From: [Nigel Ellam](#)
To: [Trees Planning](#)
Subject: Re: 2021/93790 - 46 daisy Lea Lane
Date: 11 October 2021 10:48:12

From: Trees Planning <Trees.Planning@kirklees.gov.uk>
Sent: Monday, October 11, 2021 10:34:03 AM
To:
Subject: 2021/93790 - 46 daisy Lea Lane

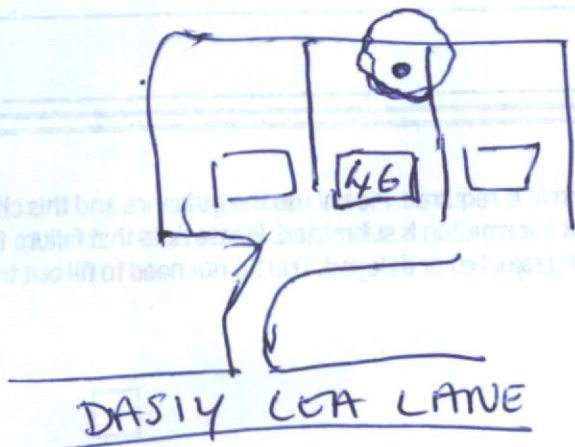
I'm emailing about your application recently validated at 46 Daisy Lea Lane, ref 2021/93790. Could you clarify which tree is to be worked on at this property? The sketch on the form shows only one tree and no details of species have been given. Looking at aerial photos it appears that there are more than one tree. It may be obvious once I've visited but it also needs to be clear in your application so could you provide with a bit more info.

Yes it's in their garden it's a beech in the corner
